Application: SSI 7485

I write regarding the proposed modification to M4-M5 Link, Mod 2 The Crescent overpass and changes to pedestrian infrastructure in North Annandale, Rozelle and Rozelle Bay Foreshore area.

Figure 4-5 The Crescent/Johnston Street/Chapman Road intersection

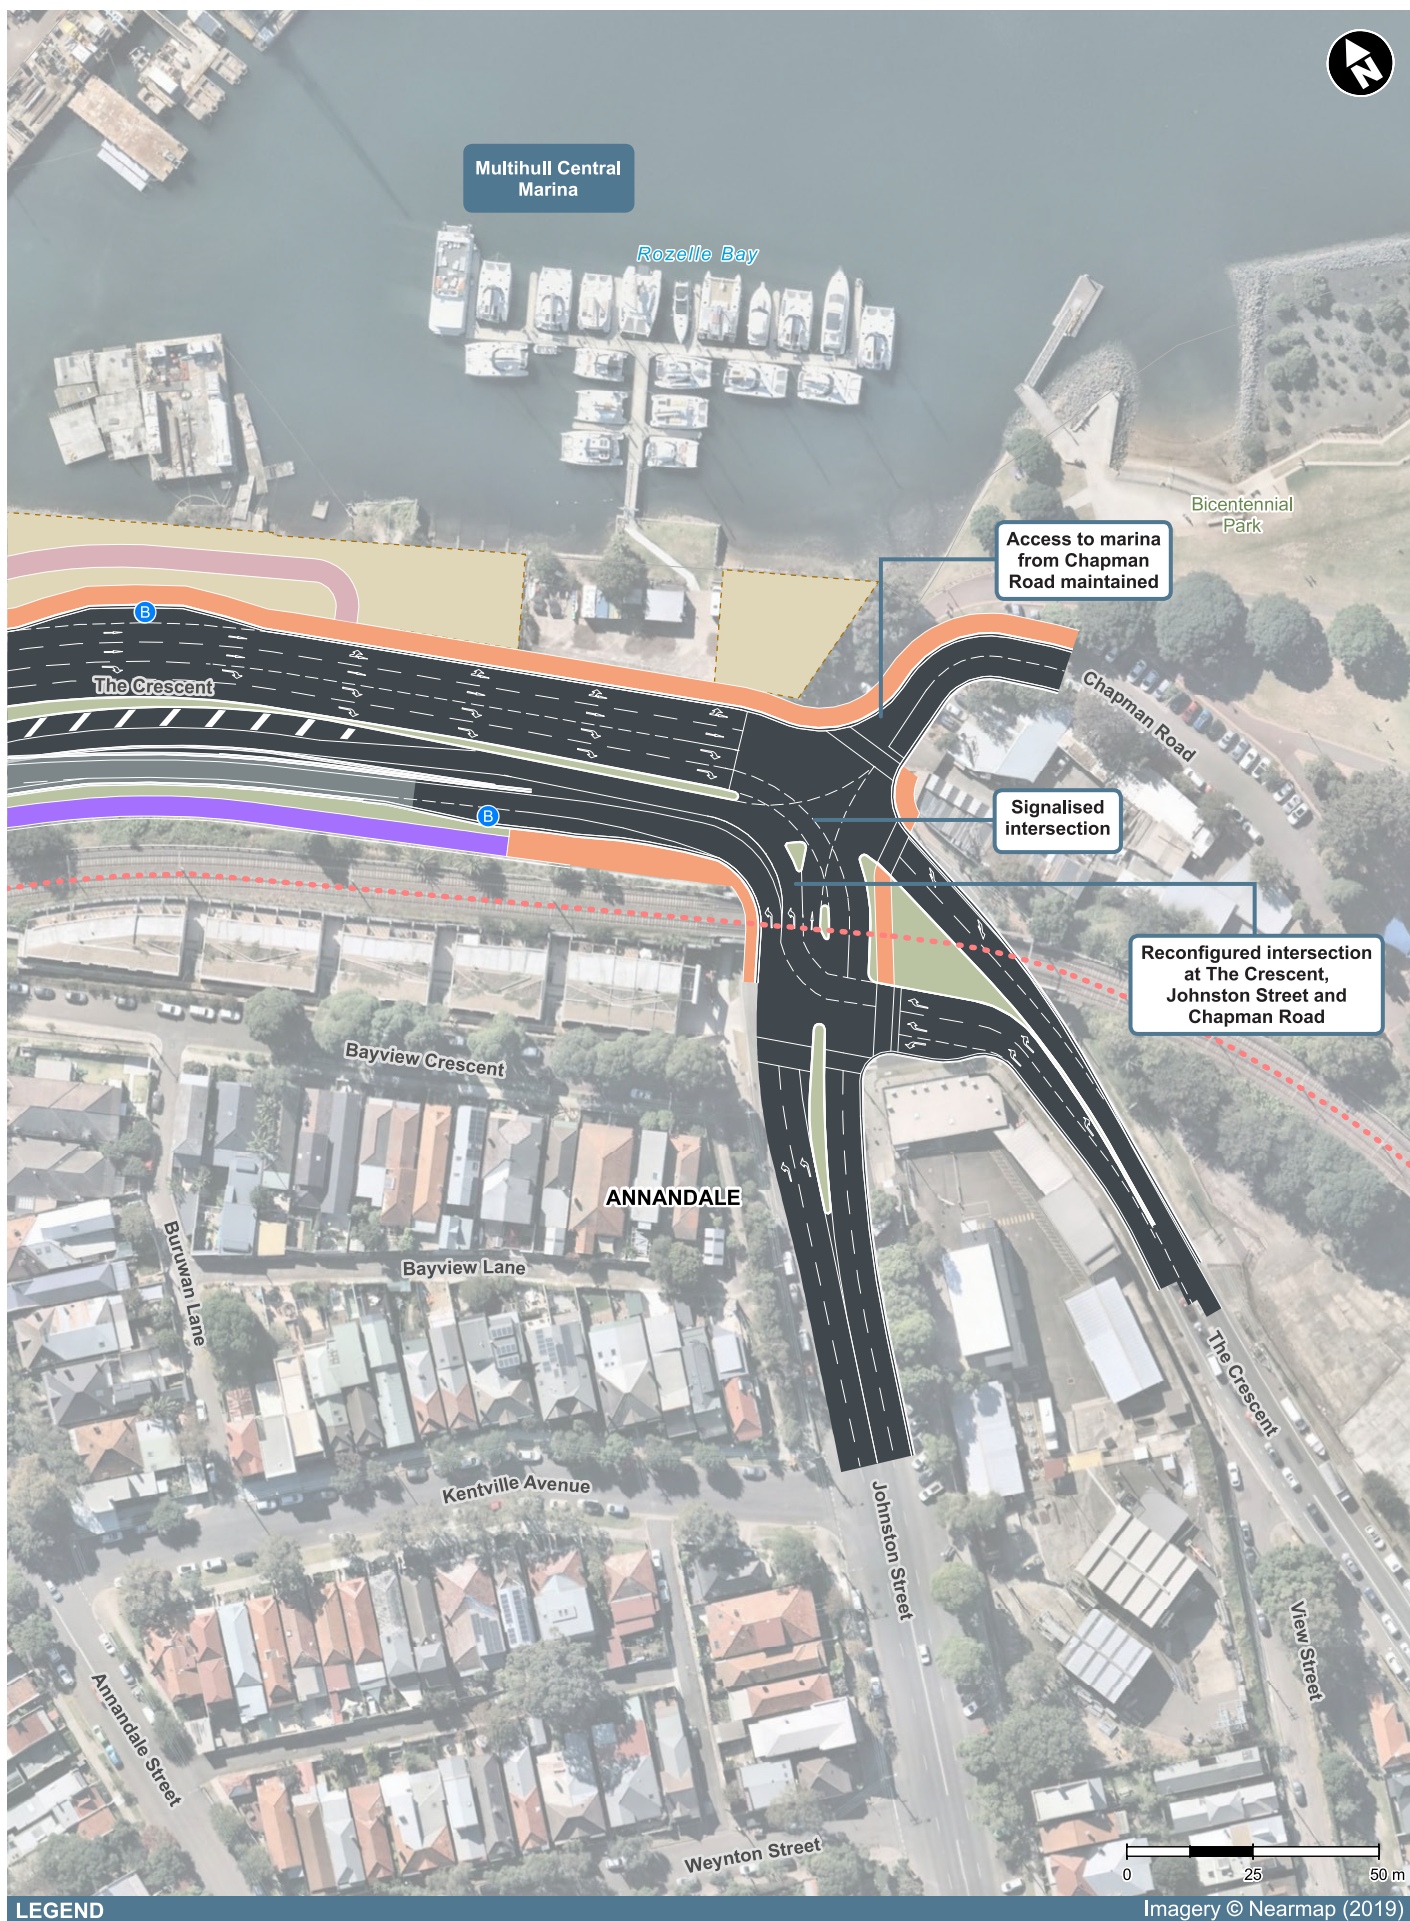
- The significantly reduced safety and increased risk for pedestrians and cyclists with removed access over The Crescent to Bicentennial Park and the increased traffic along Johnson Street.
- Being required to cross five sets of pedestrian lights at The Crescent as my option to reach the foreshore from Annandale or from Rozelle Bay light rail stop.
- Removal of direct active links to the foreshore, cutting the community off from the area and the proposed revitalisation of the entire Bays Precinct, including linking the Light Rail and Bus stops to a Ferry wharf and Metro station.
- Urban and landscape design that is being built before a finalised Masterplan for the area.
- Traffic changes that limit movements around the suburb and create further congestion in the local streets of Annandale, Forest Lodge, Glebe, Lilyfield and Rozelle with no planning to deal with these.

Figure 4-6 Elevation: Indicative view of Rozelle Rail Yards Pedestrian and Cycling Green Link

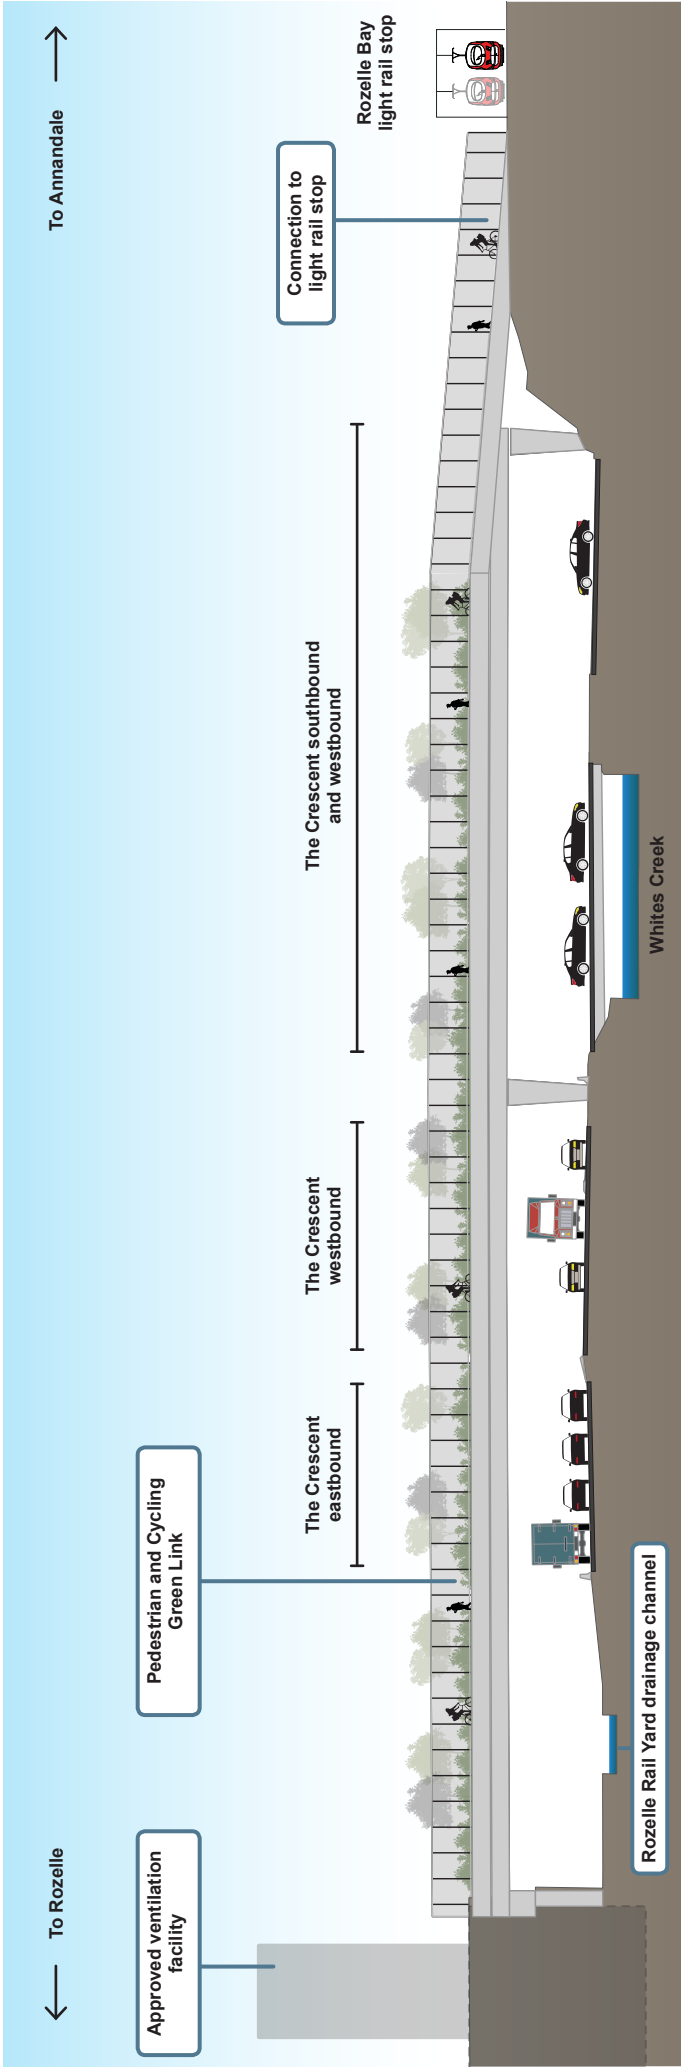
I request RMS work with the community to explore alternate design options to the proposed new car overpass design and the changed pedestrian and cyclist links. I am seeking the reinstatement of the safe, direct access from the approved EIS GreenLink to create a continuous green open space connection from the Rozelle Rail yards and Annandale to the foreshore. The GreenLink was more than just a walk way - it put people central to the design, maximising safety, and providing much needed accessible open space for the community now and into the future Bays Precinct design.

- Reinstate the GreenLink connecting communities and green open space from Rozelle to Bicentennial Park
- Relocate and design pedestrian and cyclist connections that are continuous, safe and direct.
- Design the modification infrastructure and active links in response to the character of the suburbs, the location of the foreshore and its potential future development.
- Provide pedestrian and cyclist paths that maximise people safety and do not force them onto busier streets, unsafe concrete plazas and caged walkways.
- Integrate active and direct connections to all active transport – including the future Metro West and Foreshore Ferry Wharf
